IN REPLY REFER TO:
Case No.: 15-06-0805R
Community: City of Albuquerque, NM

Identifier:	The Foothills
Flooding Sources:	Pino Arroyo (aka Arroyo del Pino or South Pino Arroyo) and Tributary 1 Pino Arroyo
FIRM Panels Affected:	35001C0161G and 35001C0142H

Summary of Additional Data Required to Support a Conditional Letter of Map Revision (CLOMR)

Geom: PINO ARROYO - EXST 2
RS = 2183.63

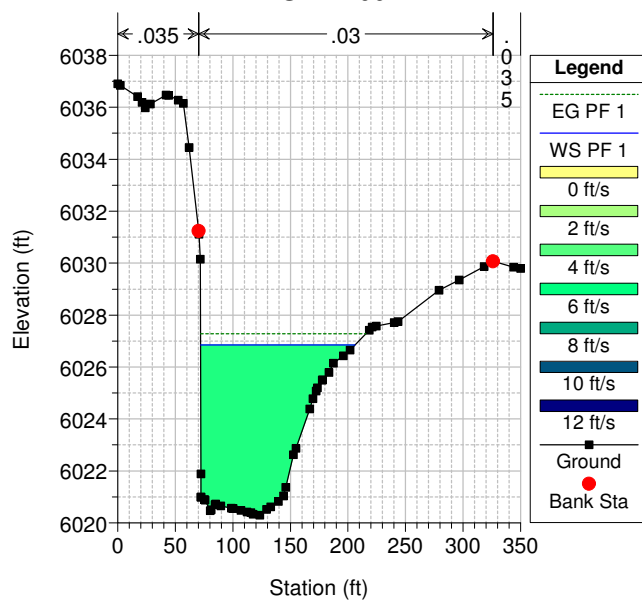
- c. Please continue to show topographic contour information used in the hydraulic model and for the boundary delineations of the base floodplain.
 - d. Cross-Sections 2183.63 and 2200 are intersecting each other. Similarly, Cross-Sections 1942.35 and 1948.66 are also intersecting. Cross-Section 1948.66 is shown on the work map but not included in the hydraulic analysis. Please ensure that all cross-sections used in the hydraulic model are shown on the work map and do not intersect each other.

RS = 1873.47

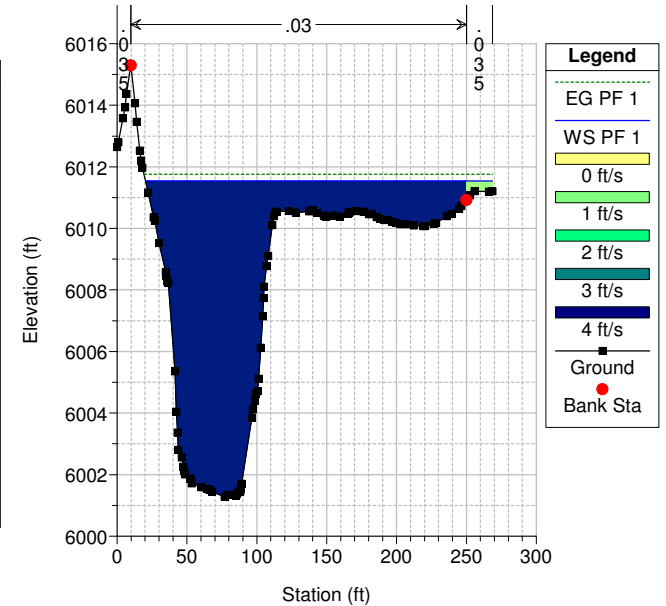
4. Our review revealed that the 1-percent-annual-chance Base Flood Elevations (BFEs) are higher than the end points of Cross-Sections 1873.47, 1086, and 1054.4 in the submitted existing conditions HEC-RAS hydraulic computer model and Cross-Sections 1086 and 1054.4 in the submitted proposed conditions HEC-RAS model along Pino Arroyo. The use of vertically extended cross-sections might both overestimate the BFEs and underestimate the width of the base floodplain. This issue was raised in our letter of January 7, 2015; however, no concrete justification was provided in this regard. Please revise the cross-section geometry coordinates so that the end points of all cross-sections are equal to or extend higher than the corresponding BFEs, or provide documentation that quantifies the amount of split flow that would occur if the cross-sections were not extended, and the extent of all flow breakouts.

PINO ARROYO - EXISTING CONDITIONS Plan: Plan 15 4/28/2015
Geom: PINO ARROYO - EXST 2

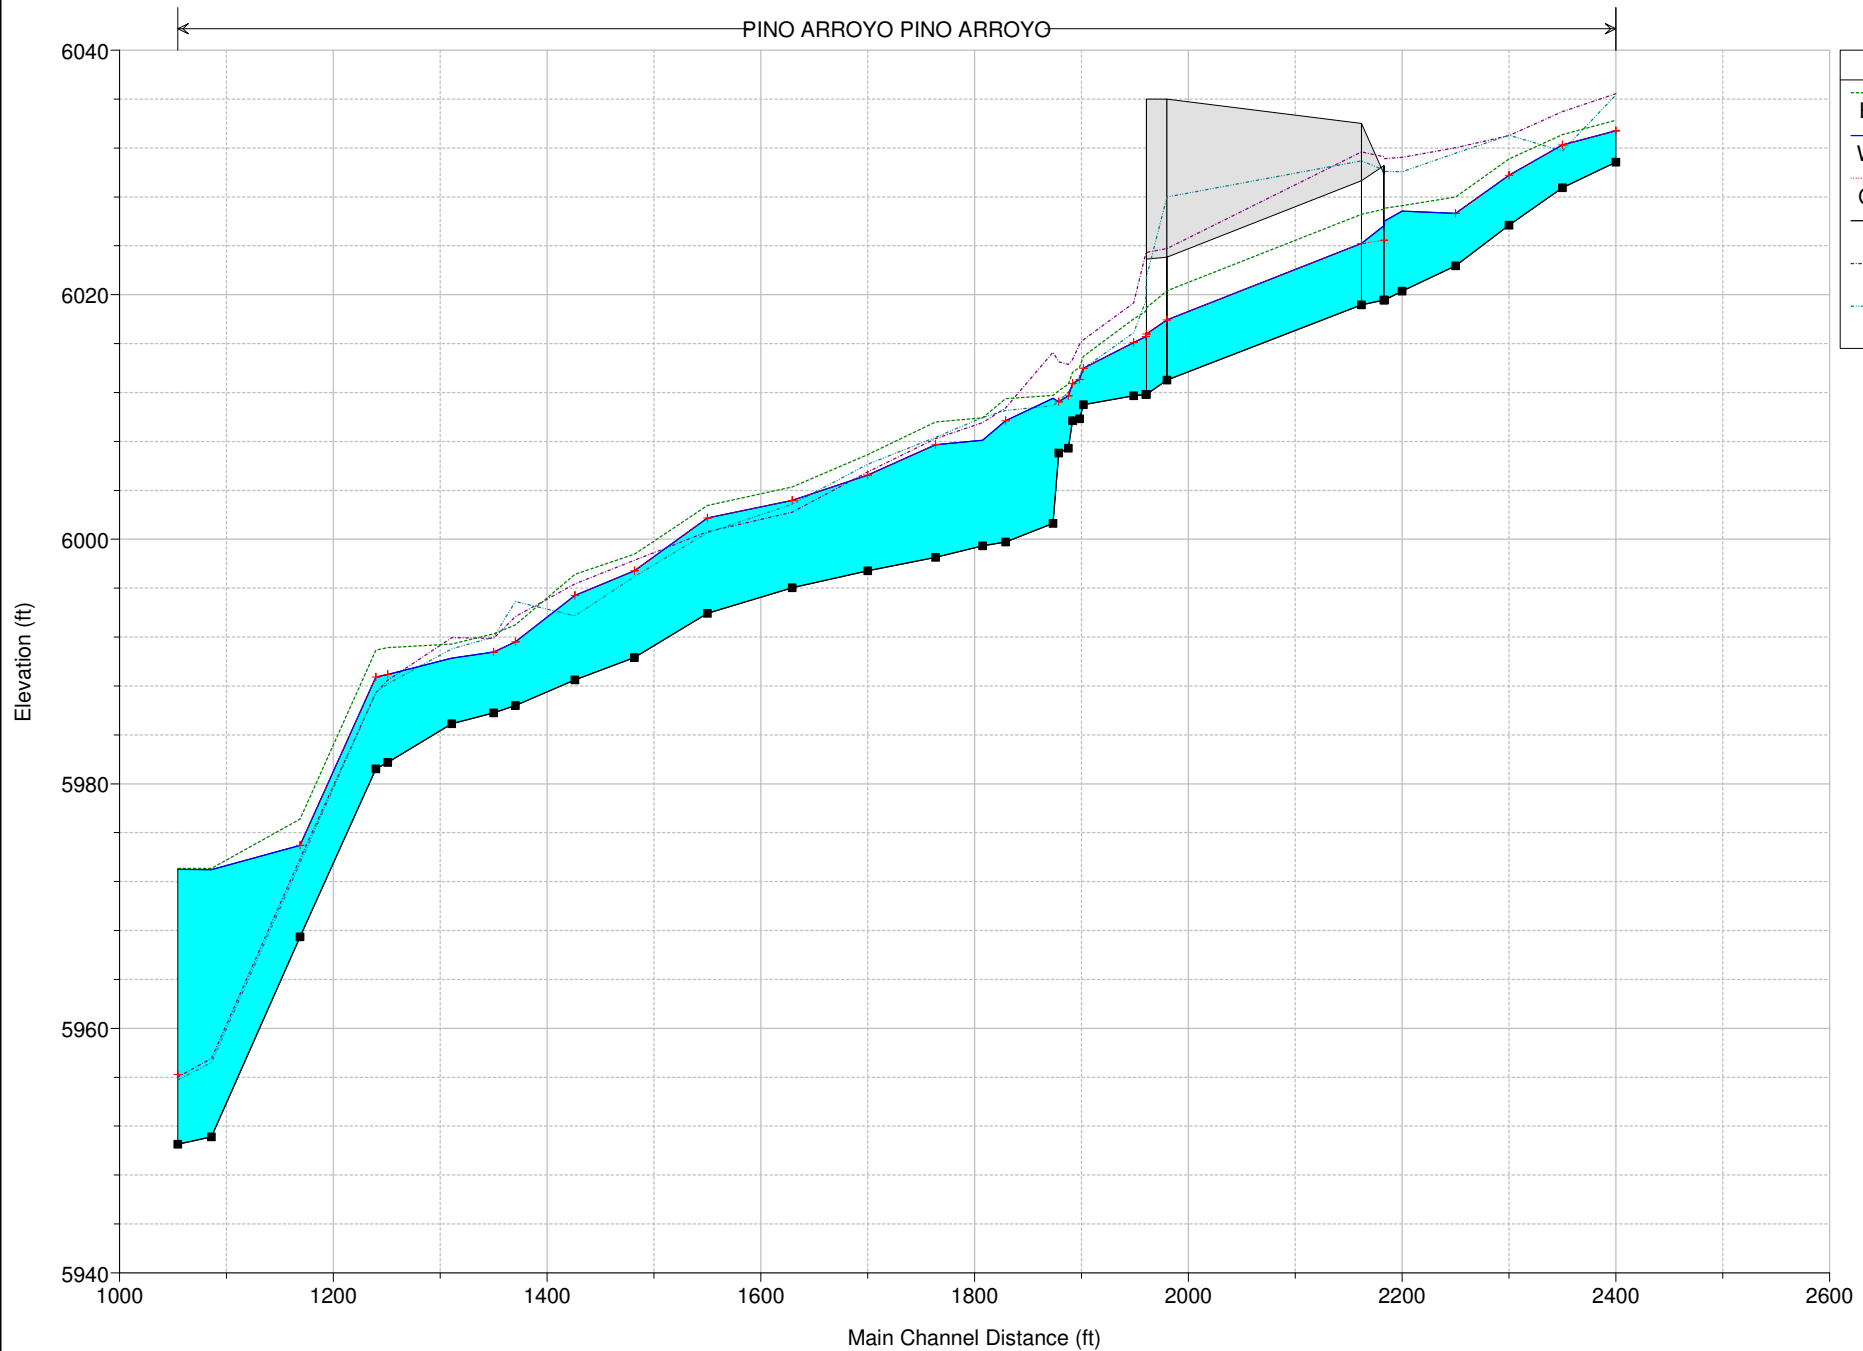
5. Our review revealed that the submitted existing and proposed conditions hydraulic models were run using the mixed flow regime. FEMA accepts base floodplain boundary delineations based on supercritical flow depths only for concrete-lined engineered channels. Because the existing and proposed channel is not concrete lined, critical depth is the minimum depth permissible to map the base floodplain boundary delineations along this reach. This issue was raised in our letter of January 7, 2015; however, no concrete justification was provided in this regard. Please revise the hydraulic analysis for this portion of the channel using subcritical modeling, or provide an explanation along with a concrete justification for not using subcritical modeling.
